EP-22-0053 Cueller Residence (Crystal Park Site S-309)

The applicant proposes a single-family residence at 570 Dayspring View in the Crystal Park development. With this referral, we received the Site Plan (Tuscany Homes, October 26, 2020), Elevation Plans (Tuscany Homes, October 26, 2020), and Subsurface Soil Investigation (Entech Engineering, Inc., stamped December 2, 2021). The Entech soils report did not address the geologic hazards associated with the site. Per County code, a soil and geology report is required that identifies geologic hazards and provides appropriate mitigation measures.

Submitted 1/18/2022 by Amy Crandall, Engineering Geologist, Colorado Geological Survey (303-384-2632 or acrandall@mines.edu)

SITE PLAN

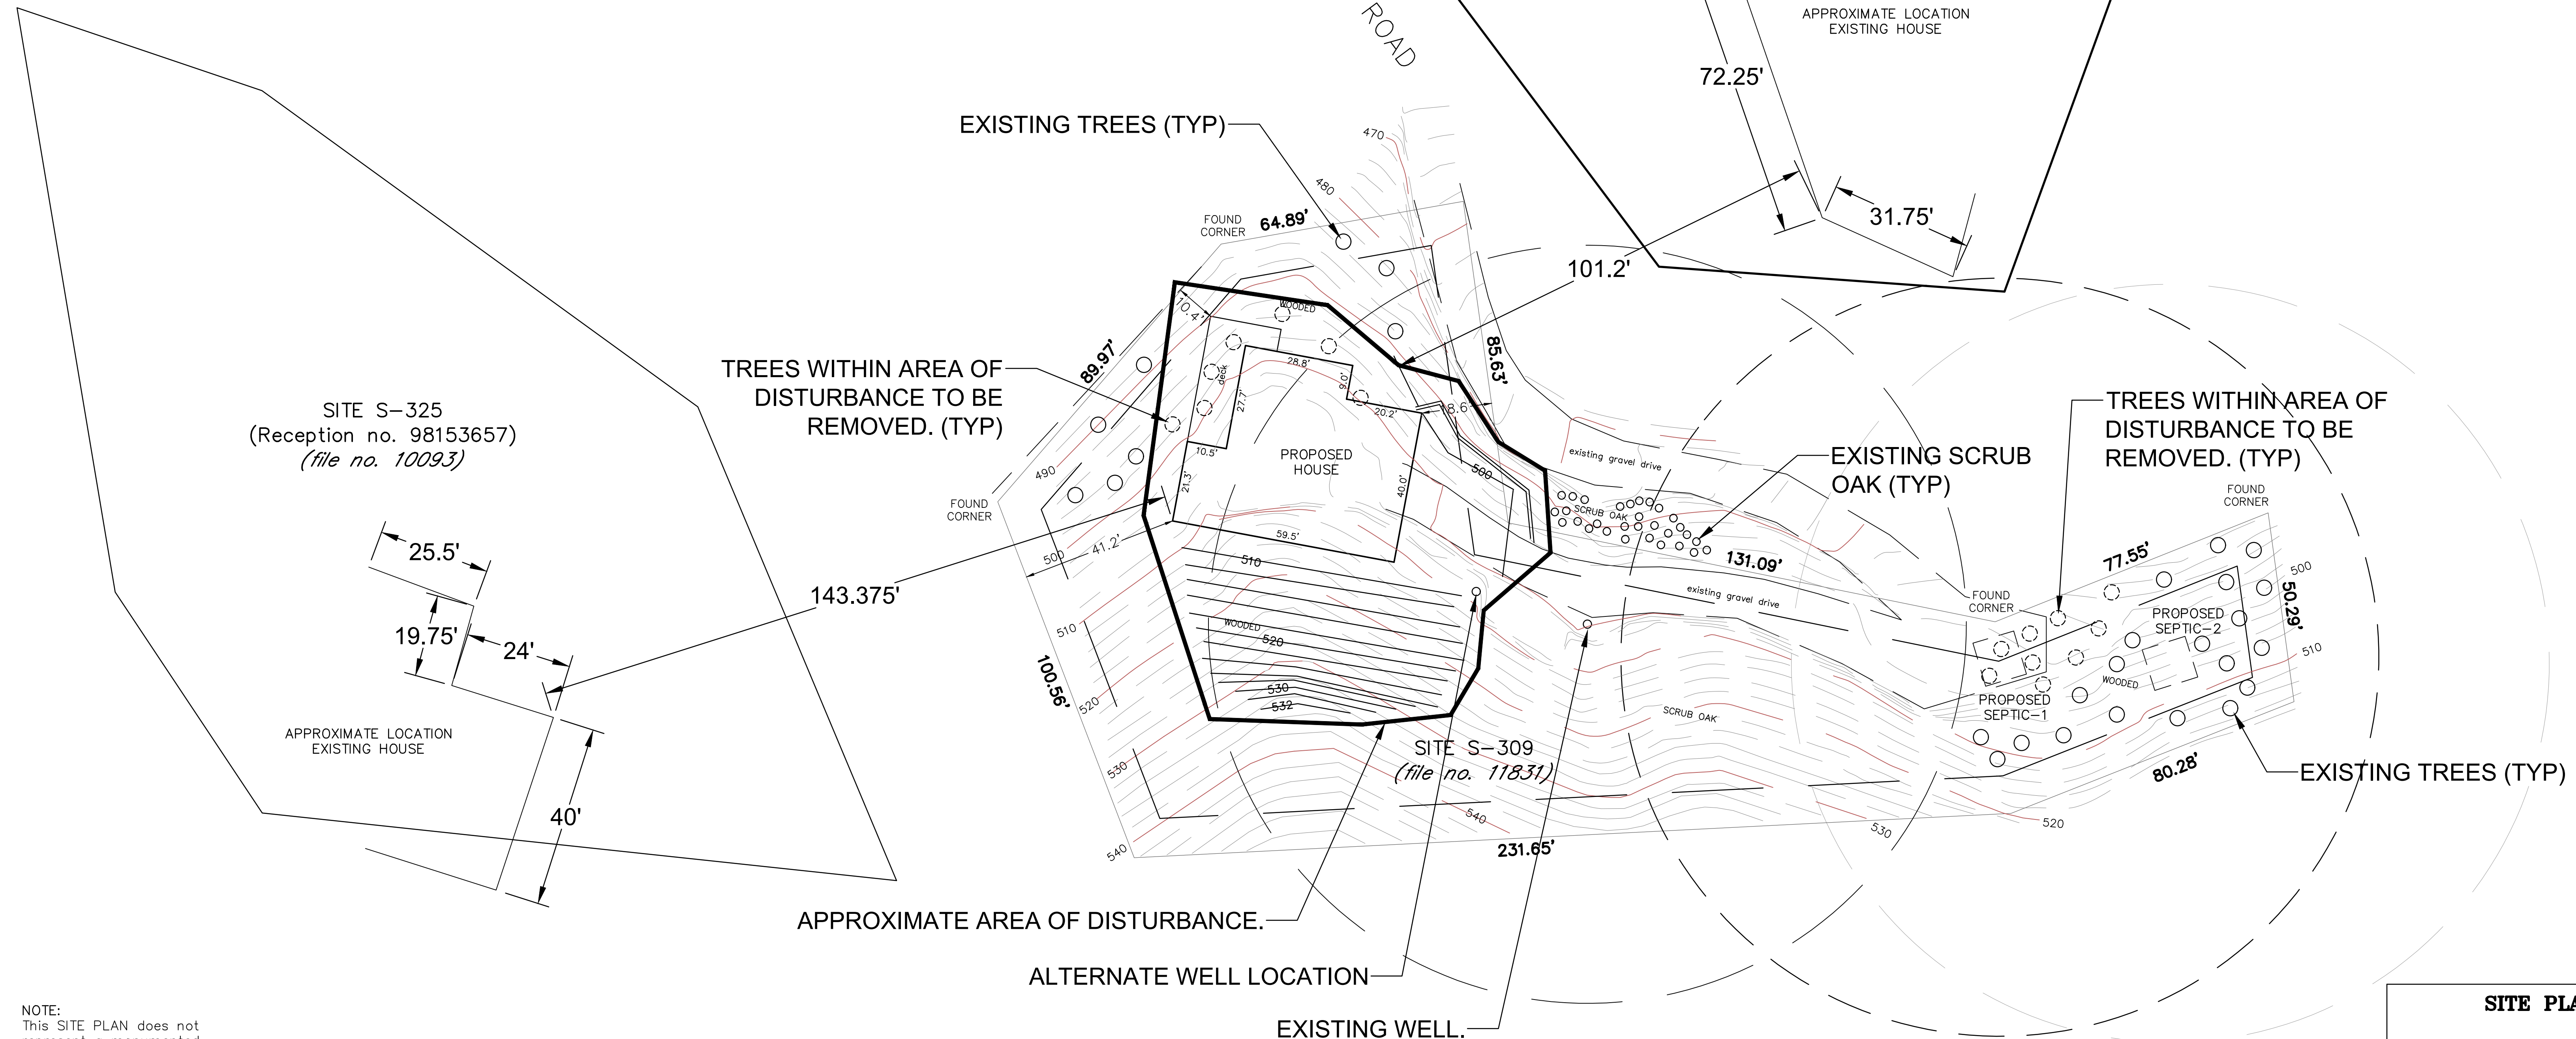
**Geologic Hazard Disclosure Statement.** CGS recommends that Entech or another qualified geotechnical engineer evaluate the geologic hazards and constraints required by county code and provide appropriate recommendations and mitigation measures. We suggest the geologic hazards and constraints be included in the preliminary/site plan.

As previously stated, the bedrock at the site is the Pikes Peak Granite, forming outcrops directly upslope (to the west). The existing rocks and boulders are likely to be disturbed during construction activities and/or freeze/thaw, resulting in an increased potential for a rockfall hazard. It may be prudent to remove such rocks during construction. **CGS recommends the county require the risk for rockfall hazards to be evaluated prior to construction.** The appropriate mitigation measures should be noted on the project plans.

- A qualified geotechnical professional should determine maximum allowable, unretained temporary, and permanent cut/fill heights and slope angles.
- All planned cuts exceeding four feet in height **should be evaluated for slope stability** using proposed slope geometry and considering all foundation and proposed cuts that will affect the slope.

- Driveway retaining walls, building foundations, and upslope walls that will function as retaining walls must be designed by a qualified geotechnical or civil engineer and must include adequate behind-wall drainage.
